From: Charlotte Easton
Sent: 20 March 2019 14:34
To: Karen Parsons
Subject: FW: The Locomotive, Wick (Refs; LU/301/18/L & LU/297/18/A)

Could you confirm who is dealing with the applications at the Locomotive, 74 Lyminster Road – reference number LU/297/18/A.

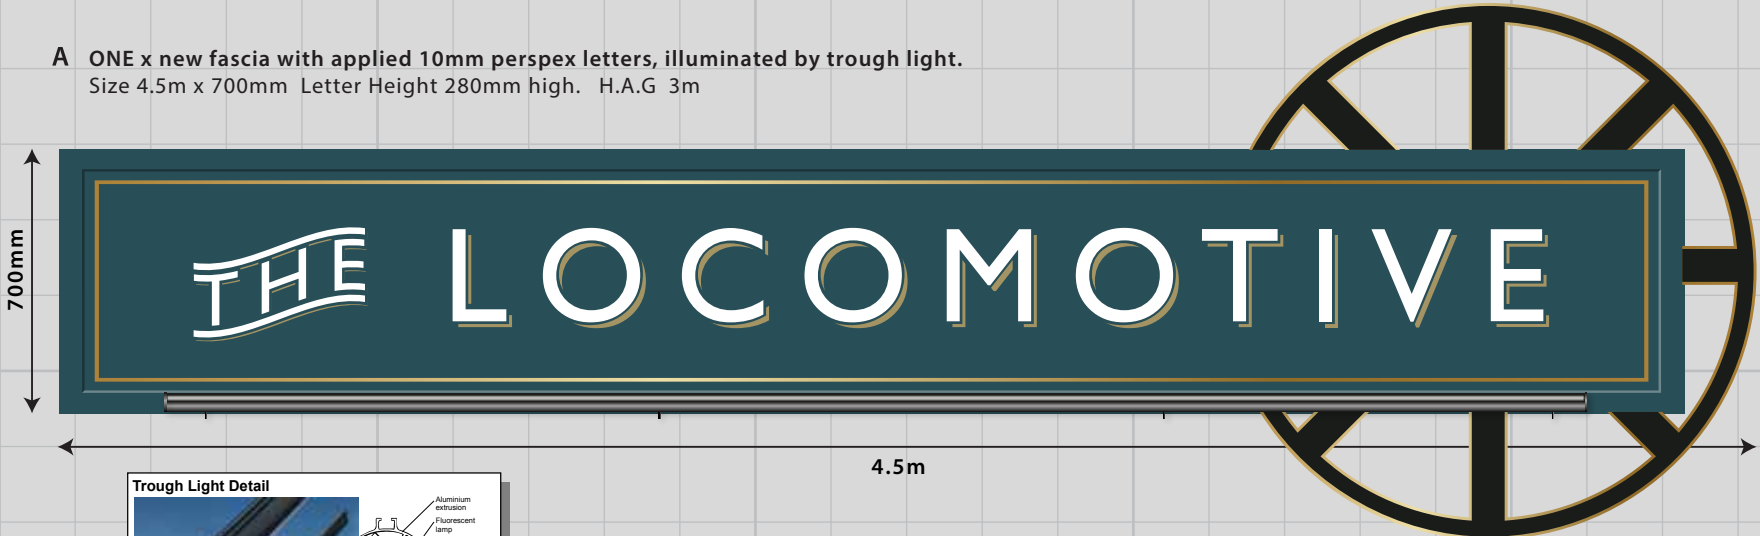
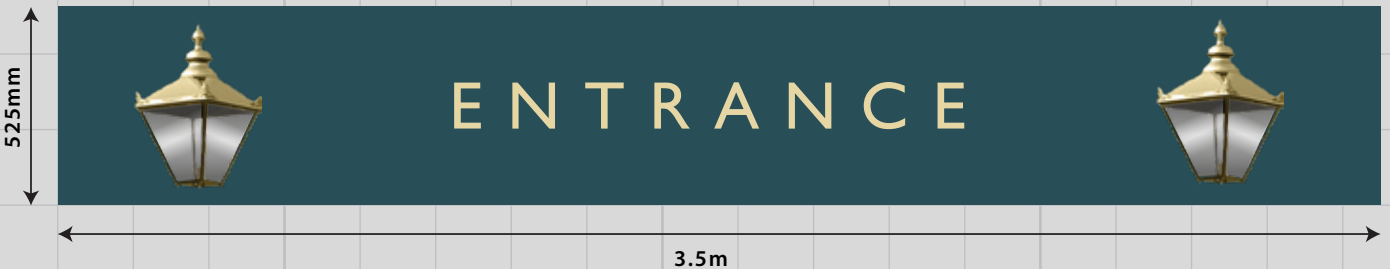
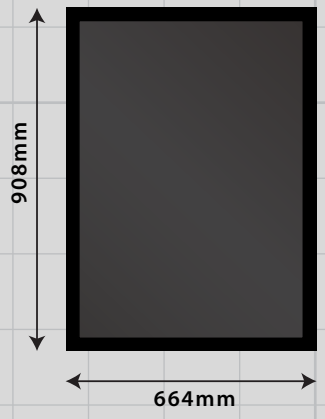
Thank you very much for the confirmation. I am just finishing the report today - I have just realised however that we will require a revised elevational drawing of the Public House to show the amendment to this application. If you could please provide a revised front elevation with three of the amenity boards removed and Sign C indicated, I will then be in a position to finish the report and pass it to my Team Leader for sign off.

He has asked you confirm which type of board would be used, his preference would be image C as shown on the signage specifications?

I have spoken with the Conservation Officer again with regard to your email and he is still not happy with the 2No Amenity boards you have suggested. Would you like to remove the 4 No. Boards from your application?

He has also asked for the tone of the proposed lighting, i.e: white or other.

Please see attached a copy of our amended planning drawings showing a single amenity board to the building with a lockable poster case within the bullnose frame.

This will reduce the proposed amount of amenity signs to the frontage from 4no to 1no, which is the same as shown on the previously issued historical photograph.

Yes, the proposed amenity to the front elevation would be as per Sign C. We would then apply a lockable poster case to the sign board (with frames painted to match the sign) with a permanent message behind them. This would give us the opportunity to display a permanent message, but with the option to display seasonal messages/offers as required. By painting out the frames to match the sign colour, from a distance, this would hardly be visible.

- Signs C & F – 4no signs would be excessive on this elevation – could we remove the 2no amenity boards, and retain Sign F.
- Sign H – These lights would be 30w LED fittings and would be positioned and angled in such a way to highlight the building and avoid any light spillage.
